Our Case Number: ACP-323980-25

Re: Proposed Water Supply Project for the Eastern and Midlands Region
in the counties of Clare, Limerick, Tipperary, Offaly, Kildare, and Dublin.

Re: Project name: Water Supply Project Eastern and Midlands Region
Subject: Strategic Infrastructure Development
Planning Application for the Water Supply Project Eastern and Midlands Region in the counties of Clare, Limerick, Tipperary, Offaly, Kildare and Dublin.

Drawing Title
Figure 4.64
WATER TREATMENT PLANT
ACCESS ROAD
LAYOUT PLAN AND CROSS-SECTION

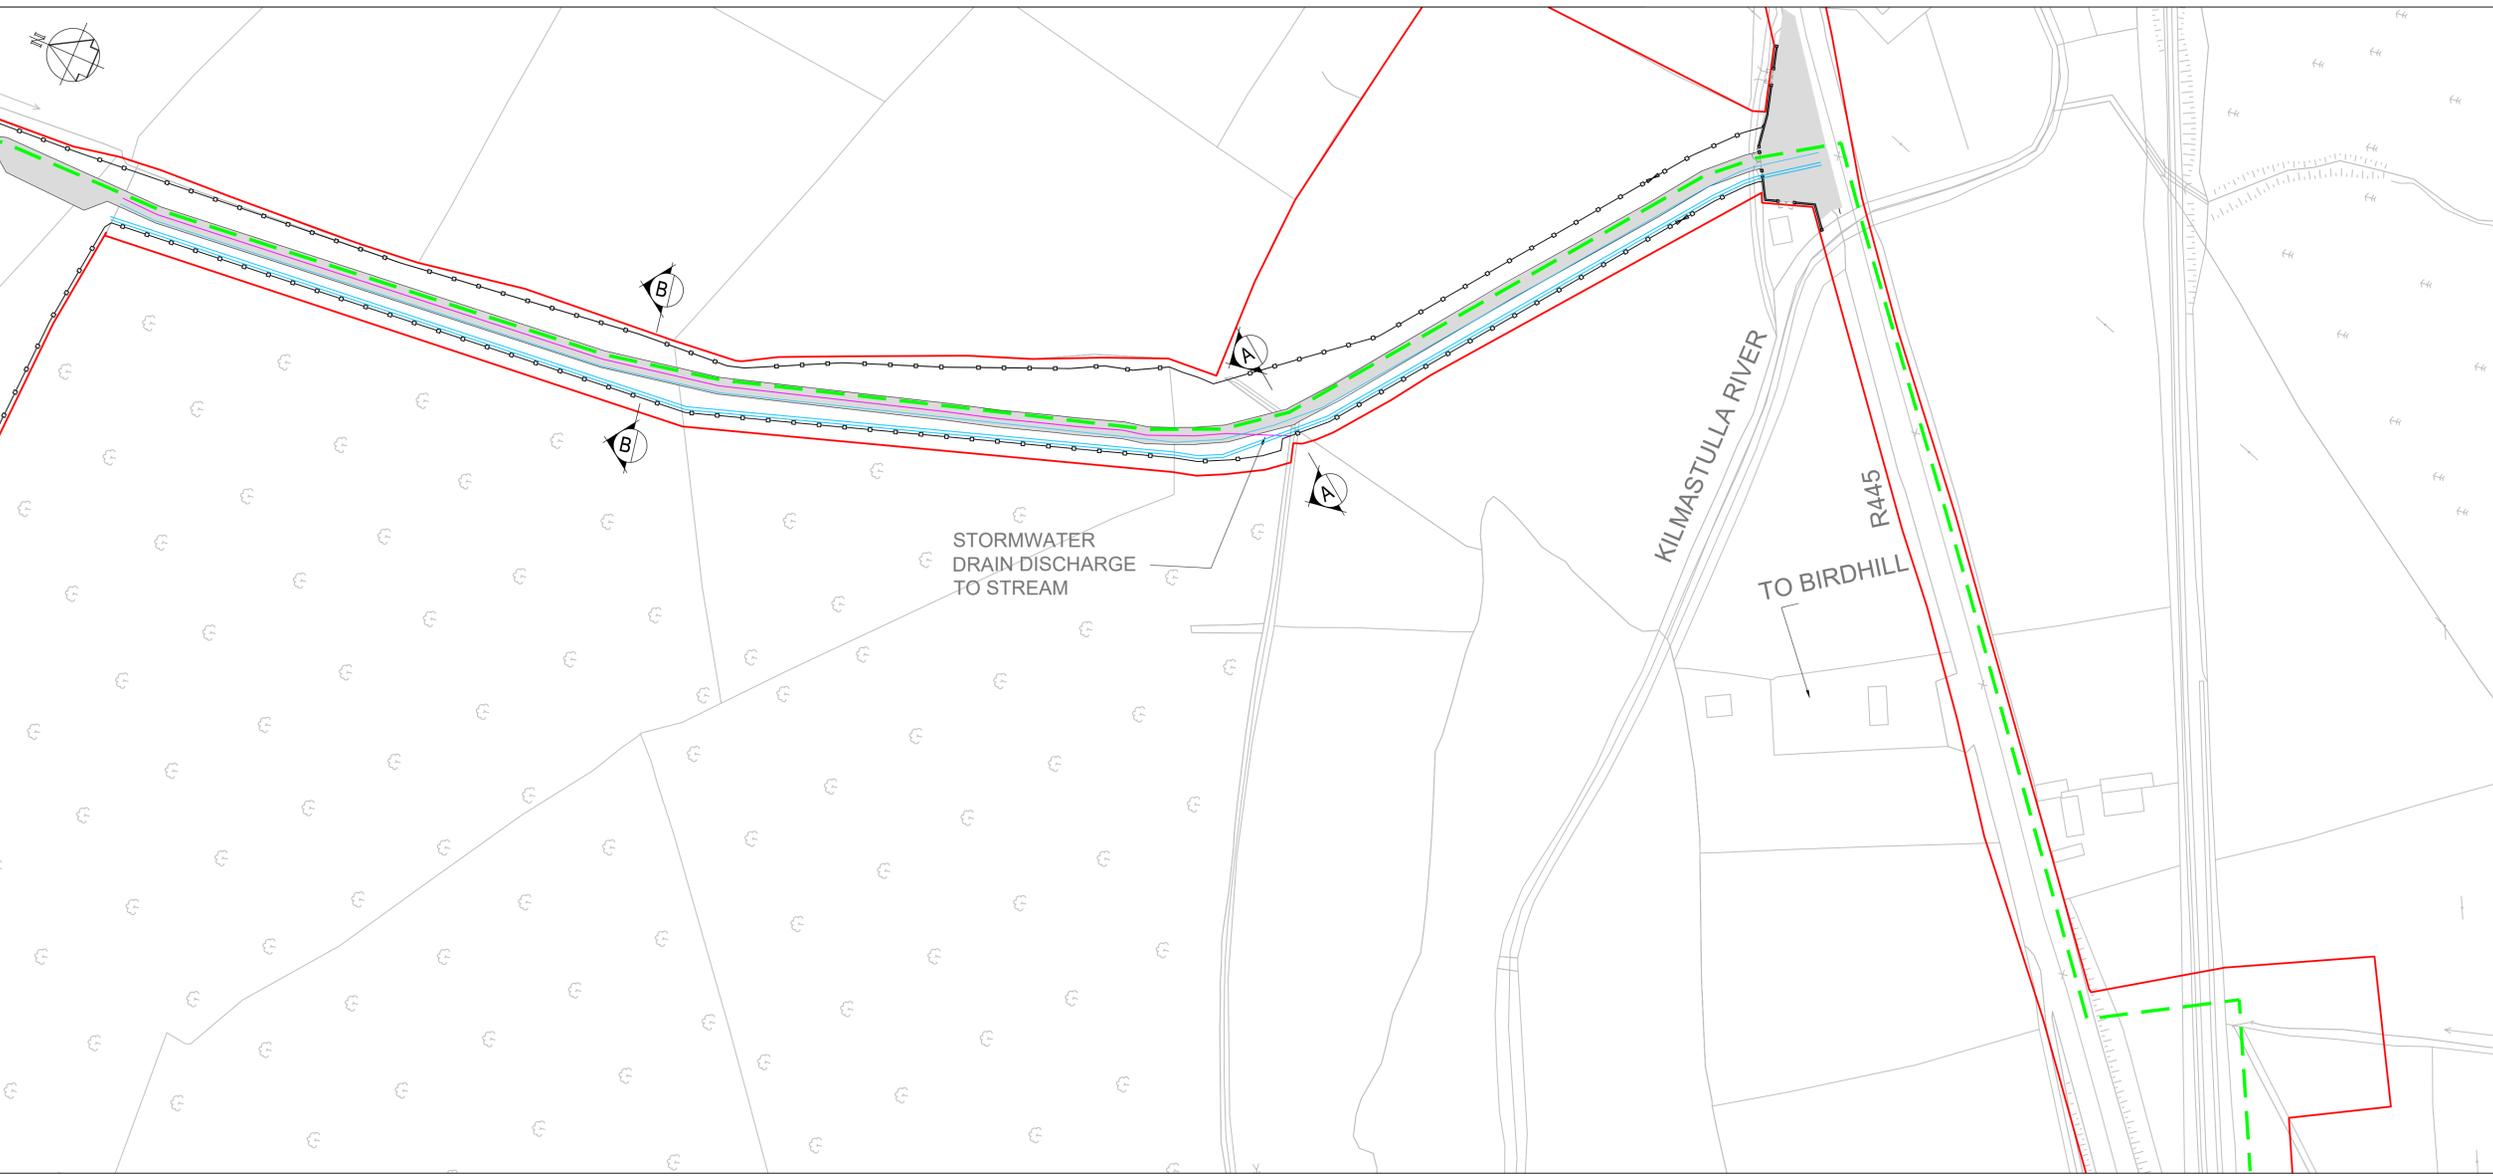
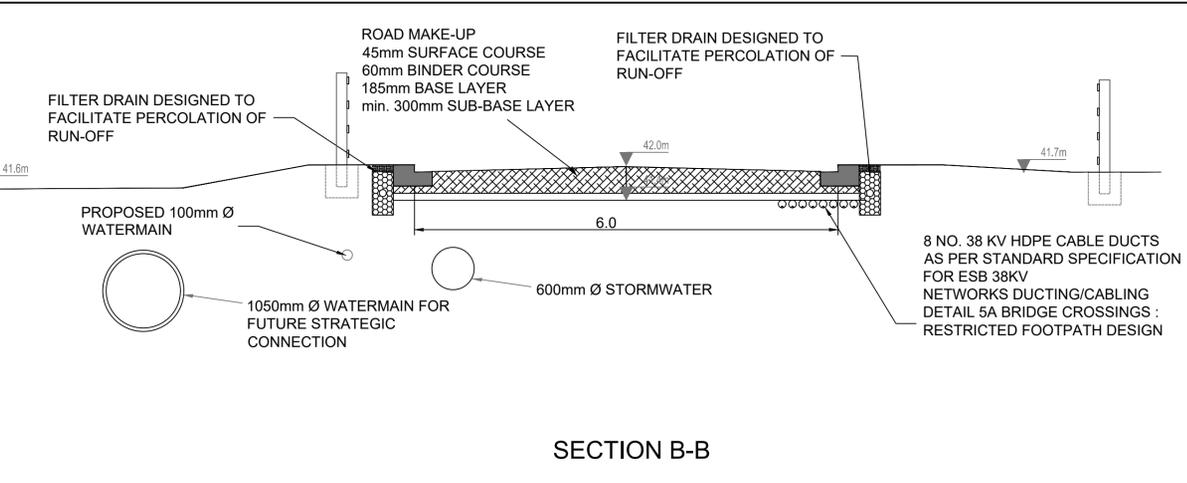
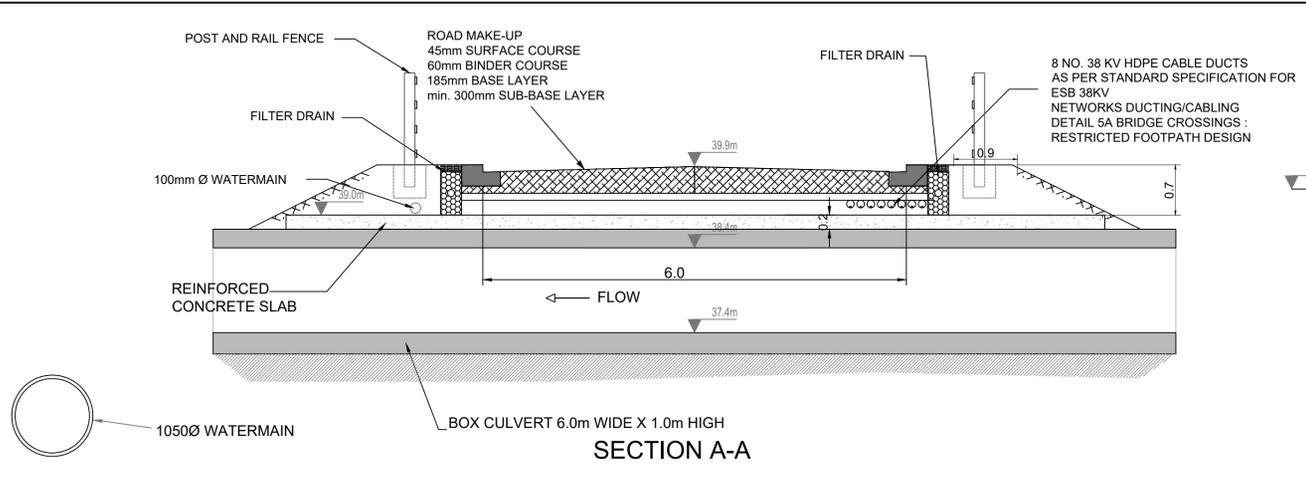
We note with concern that there is a large pipeline (600mm) connecting the WTP site to a stream off site i.e.

“309. Stormwater from the attenuation pond would be discharged into a manhole at the head of the WTP Access Road. This manhole would contain a flow control device which would control discharge from the system, limiting it to the maximum flow that would be expected from the greenfield site calculated as 239l/s. The flow would then be conveyed by a 600mm diameter stormwater drain running along the route of the WTP access road to discharge into the stream crossed by the proposed access road approximately 220m north of its junction with the R445.”

Will this pipe also be used, after planning permission is granted, to discharge the wastewater into the stream using the risk and fear of introducing *Cryptosporidium* into the drinking water supply as an excuse?
